SUFFOLK ENERGY ACTION SOLUTIONS'**REBUTTAL TO NGET RESPONSE TO SEAS RELEVANT REPRESENTATION ON
LANDSCAPE AND VISUAL****SEA LINK: EN020026****SEAS IP:** [REDACTED]**DEADLINE: 2 – December 9, 2025****Date: 9 Dec 2025**

**[\[REP1A-043\]](#) - 9.34.1 Applicant's Comments on Relevant Representations
Identified by the ExA - Specifically Table 2.51 SEAS – Landscape and Visual****Procedural Introduction**

Table 1.2 Assessment of effects on Representative Viewpoint 2: B1121, south of Saxmundham, looking east at construction and at operation and maintenance (year 1 winter and year 15 summer)

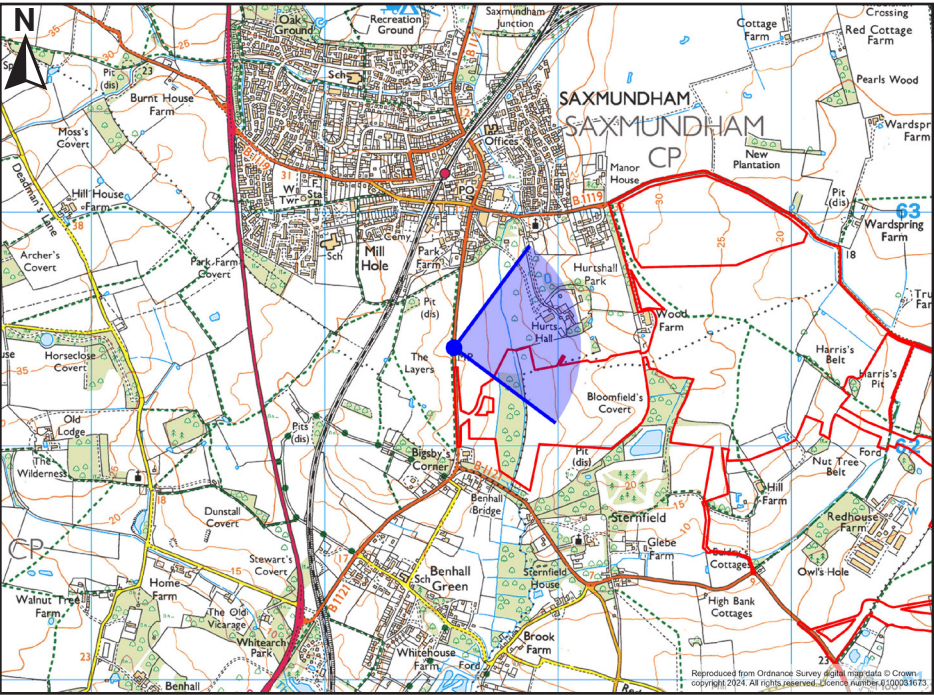
<i>3.4 VP2 is presented as key, yet converter station will be visible through a break in screening. No mention of visibility of proposed land bridge.</i>	<i>APP-098 assesses VP2 and includes River Fromus bridge.</i>	The ES omits visibility of the proposed land bridge, a critical omission. Breaks in screening mean VP2 will experience direct, unmitigated views of infrastructure. This undermines claims of limited impact.
<i>3.5 MBELC Appendix 3 shows inconsistent judgments across receptors. Minor detractors are overemphasised while</i>	<i>MBELC selectively applies assessments. Full LVIA summary in APP-048 Tables 1.10–1.12. GLVIA3 emphasises</i>	“Professional judgement” cannot excuse systematic understatement . MBELC demonstrates clear inconsistencies: minor

**Table 1.4 Assessment of effects on Representative Viewpoint 4: Public Bridleway (Sternfield 491, route 10) south of the B1119, southeast of Saxmundham, looking west at construction and at operation and maintenance (year 1 winter and year 15 summer)**

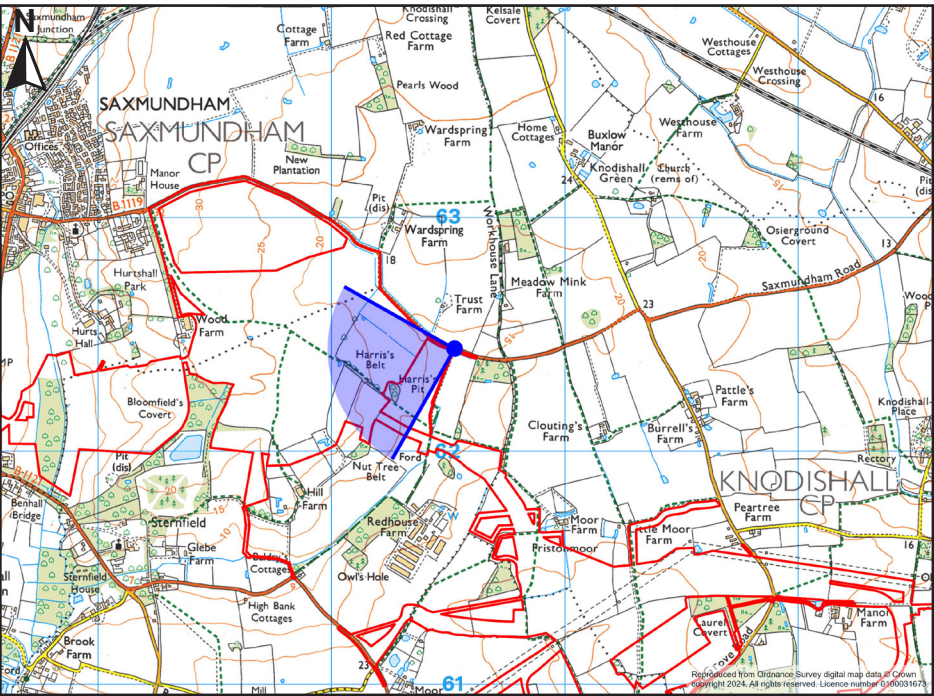
CA.. The disparity between VP2 and VP20 ratings undermines confidence in the LVIA's consistency.
<i>3.2 VP4 shows very high sensitivity and large magnitude of change yet classified only as moderate adverse — evidence of methodological compression.</i>	<i>At construction and Year 1, VP4 is judged major adverse. At Year 15, mitigation planting reduces magnitude to large, effect downgraded to moderate adverse.</i>	Mitigation assumptions are speculative. Planting cannot screen bulk/height of converter station in elevated/open surroundings. Downgrading from major to moderate adverse is methodological compression that masks long-term severity.
<i>3.3 APP-364 acknowledges converter station risks “creating a dominant presence” (VP4) and tallest structures rising above canopy (VP15).</i>	<i>APP-364 is a Design Approach Document, not LVIA. VP2 is a key viewpoint with design principles applied. APP-098 assesses effects including River Fromus bridge.</i>	Whether LVIA or design document, applicant's own evidence concedes dominant presence and canopy exceedance. These admissions confirm severe visual harm. Attempting to separate APP-364 from LVIA does not negate the reality of acknowledged dominance.
